WELWYN HATFIELD BOROUGH COUNCIL – DEVELOPMENT MANAGEMENT
DELEGATED REPORT

APPLICATION No: S6/2013/2416/S73B

SITE ADDRESS: LAND AT ESSENDON COUNTRY CLUB, BEDWELL PARK

DESCRIPTION OF DEVELOPMENT: VARIATION OF CONDITION 2 (APPROVED PLANS) OF PLANNING PERMISSION S6/2013/1087/FP - ERECTION OF TRIPLE GARAGE IN LIEU OF PREVIOUSLY APPROVED GARAGE

DRAWING TITLE
Garage

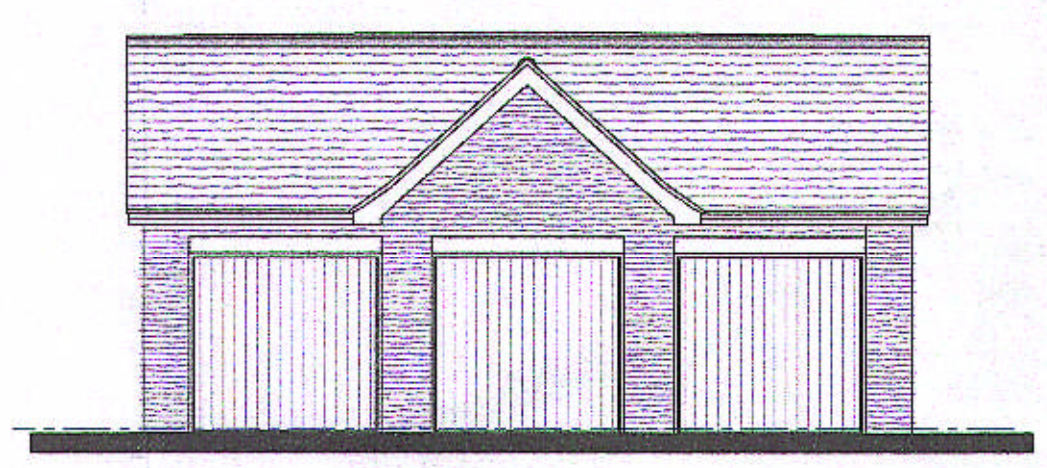
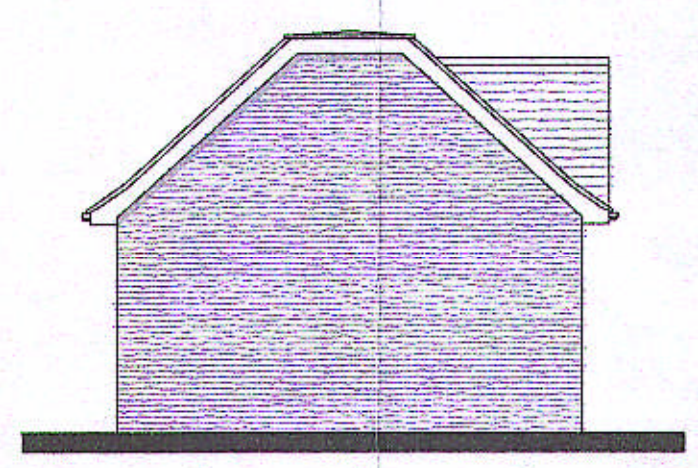
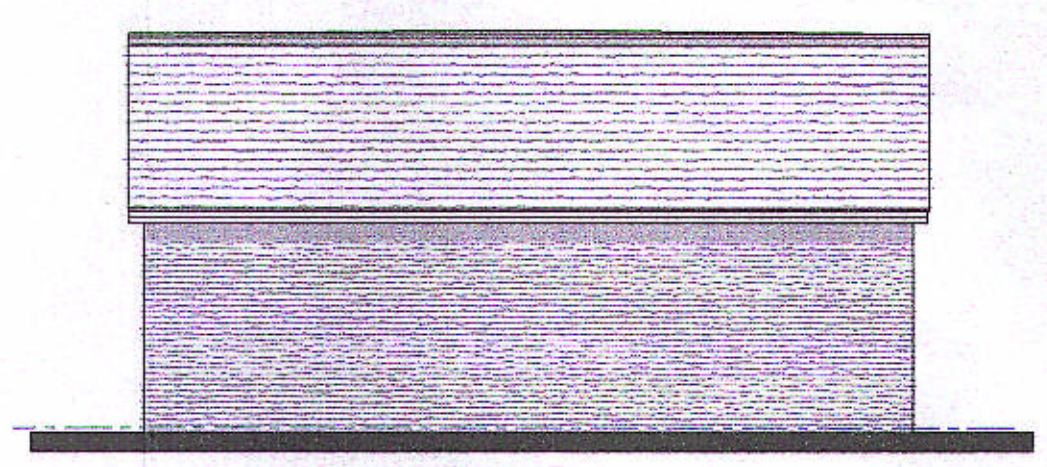
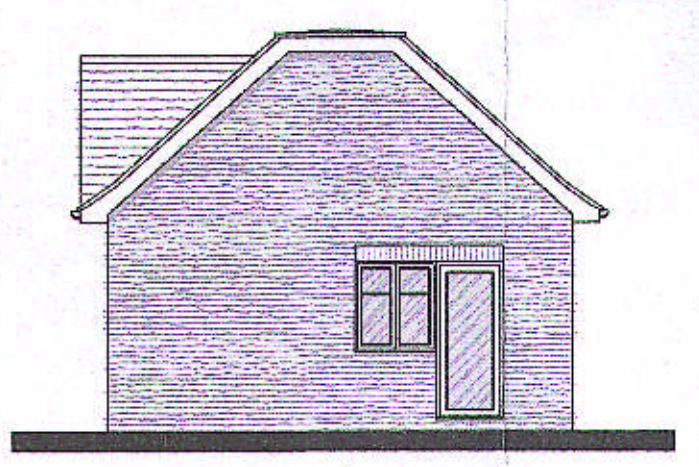
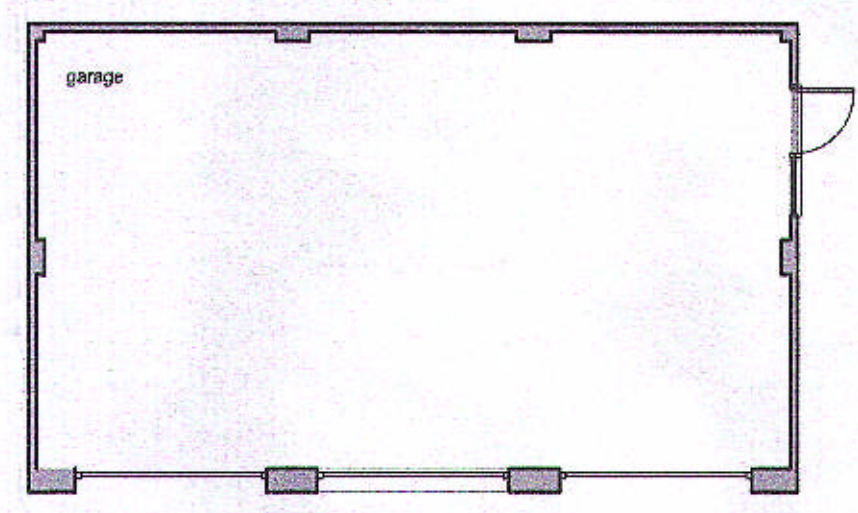
The proposal seeks the variation of condition 2 so that the previously approved double garage can be enlarged to a triple garage.

The latest drawing (13/ECC/PL/06/A) shows a triple garage design and location and updates drawing 13/ECC/PL/02C. Previously approved drawings 13/ECC/PL/03A & 13/ECC/PL/04A have been amended to delete the double garage and have been given an updated revision to 13/ECC/PL/03B & 13/ECC/PL/04B.

This application is seeking permission for a larger garage than that granted under the earlier approval. Permitted development rights have been removed, including for outbuildings, and so detached garages which can sometimes be constructed without planning permission will always require a planning application for this site. The reason why permitted development rights were removed was because the replacement dwelling is materially larger than the existing dwellings by 30%. However, the existing dwellings (now demolished) had never been extended, and so had the potential to be extended further. This formed part of the very special circumstances case.

There is no clear policy guidance for this type of situation, and so it is up to the decision maker to make a planning judgement. Taking into account that the size of the increase to the garage would be very limited compared to the rest of the approved development, and that the site is:

- well screened
- there would be limited impact on the openness of the Green Belt
- the design would be in keeping
- for non-habitable accommodation
- is for an outbuilding rather than a further extension to the main dwelling.

Then, on balance, it would be reasonable to conclude that very special circumstances exist to justify also this proposal as there would be no significant harm to the openness of the Green Belt.

Pulham House is the nearest neighbour to the proposed development. The changes proposed are sufficiently distant from this neighbour such that there would be no material impact on their residential amenity.

The design of the resultant garage would be in keeping with the character of the approved dwelling and surrounding area and so would meet all the design requirements of the local plan.

The location of the proposed development would not impact on any existing trees.
